A | 419 King Street
Newtown NSW 2042
P | 02 9168 9893
E | admin@wmseng.com.au
W | wmseng.com.au
ABN | 85 700 247 836
Ref | 20345-L01-2
Date | 16 January 2026

24-28 Middle Harbour Road, Lindfield – Response to NSW SES Feedback

The Proponent has received feedback from the NSW State Emergency Service (SES) following the submission of the Flood Impact and Risk Assessment (FIRA) as part of the EIS submission for the SSD (SSD-82548708). The responses are identified below and references are provided to show where they are addressed in the updated report.

Figure 4-5 1% AEP Flood Level Afflux

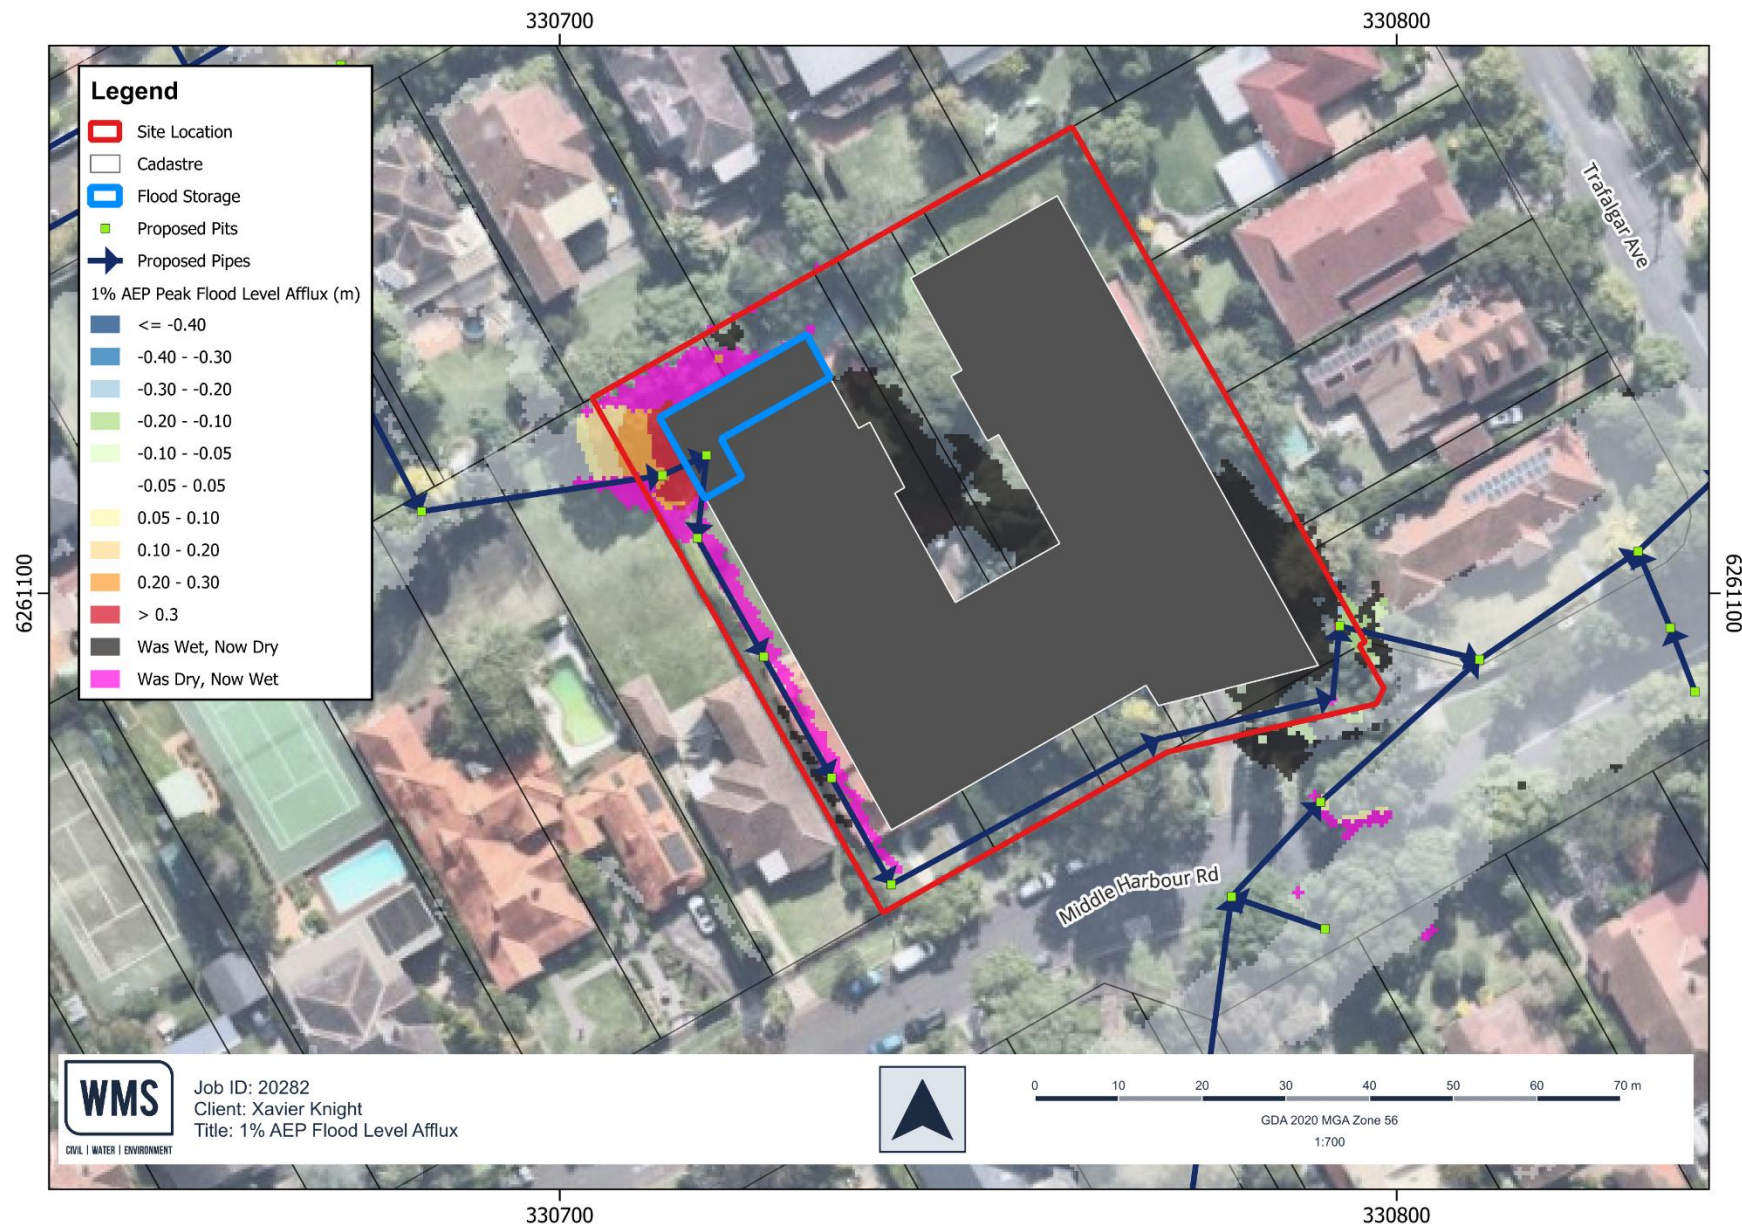
During the PMF the site currently becomes inundated to depths of up to 1 metre, but under post-development conditions becomes inundated to depths of up to and greater than 2 metres. The afflux maps also indicate that the proposed development would increase flooding on adjacent sites to the north, west and south of the site during the PMF by up to and greater than 0.3m, and would introduce floodwater to properties and parts of properties that would otherwise have been dry. This proposal would therefore impact on the existing community, and we recommend removing the statement “the proposed development results in limited flood level afflux within neighbouring properties” as this does not hold true for all events up to the PMF.

It is acknowledged that in the PMF event there is increase in flood levels on adjacent sites to the north, west and south. However, in the north and west, the increase is contained to the rear of the adjacent properties and therefore does not result in a worsening of evacuation ability of these properties, which can still evacuate through their frontage to Russel Avenue or Middle Harbour Road. The increases in flood levels in the south of the site are contained within the road reserve, which under pre-development conditions is already subject to inundation and therefore would not serve as an evacuation route.

The statement “the proposed development results in limited flood level afflux within neighbouring properties” has been amended to “the proposed development results in limited flood level afflux within neighbouring properties and Middle Harbour Road in all modelled events up to and including the 0.2% AEP event”.

Figure 4-6 PMF Duration of Inundation

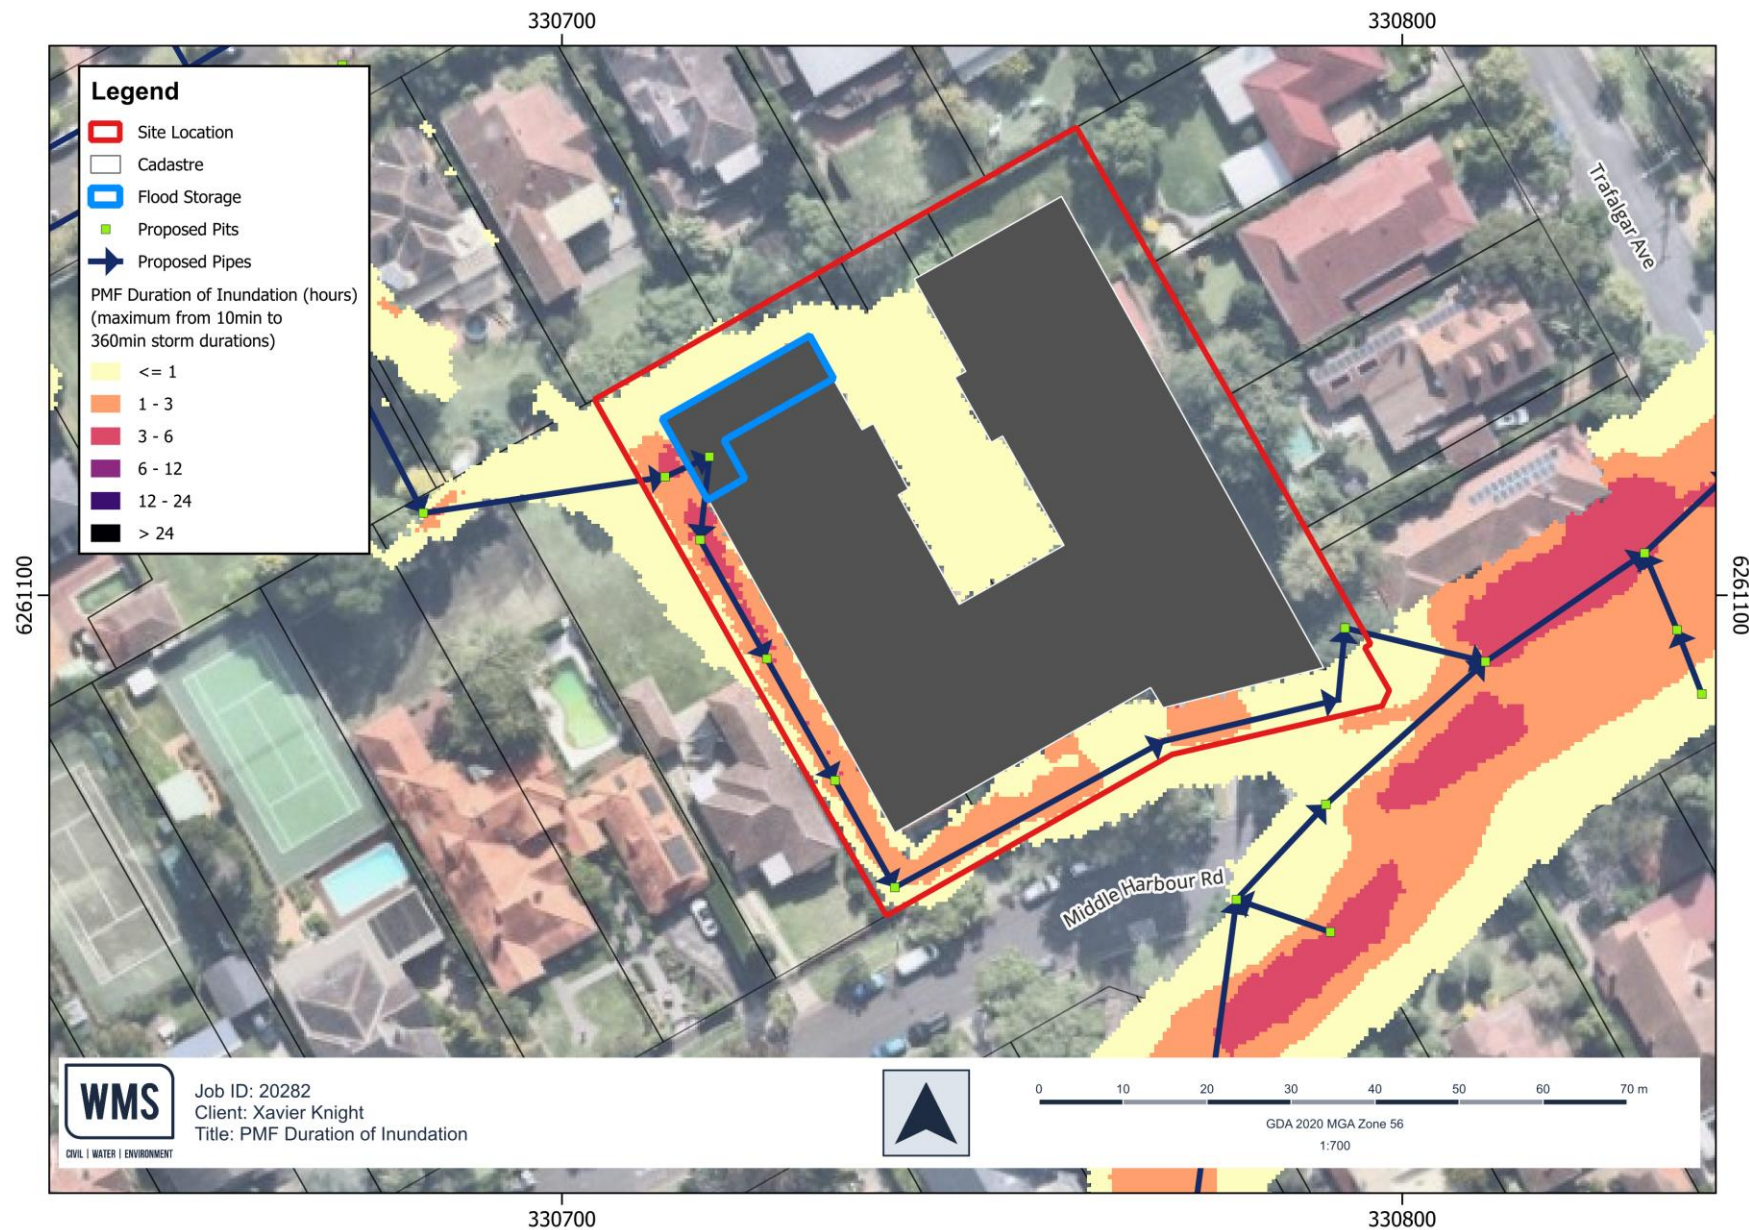
Risk assessment should consider the full range of flooding, including events up to the Probable Maximum Flood (PMF) and not focus only on the 1% AEP flood. For example, section 5 of the FIRA states "Duration of inundation ... is expected to be less than 1 hour in 1% AEP storm event", however there is no mention of duration for events greater than the 1% AEP.

Response: The FIRA has been updated to include mapping and discussion on the duration of inundation for the PMF event (refer Section 4.2 and Figure 4-6 of the FIRA). These results show that, across most of the site, hazard at or higher than H3 is not expected to last longer than 3 hours, with some localised areas within the proposed swale lasting up to 6 hours.
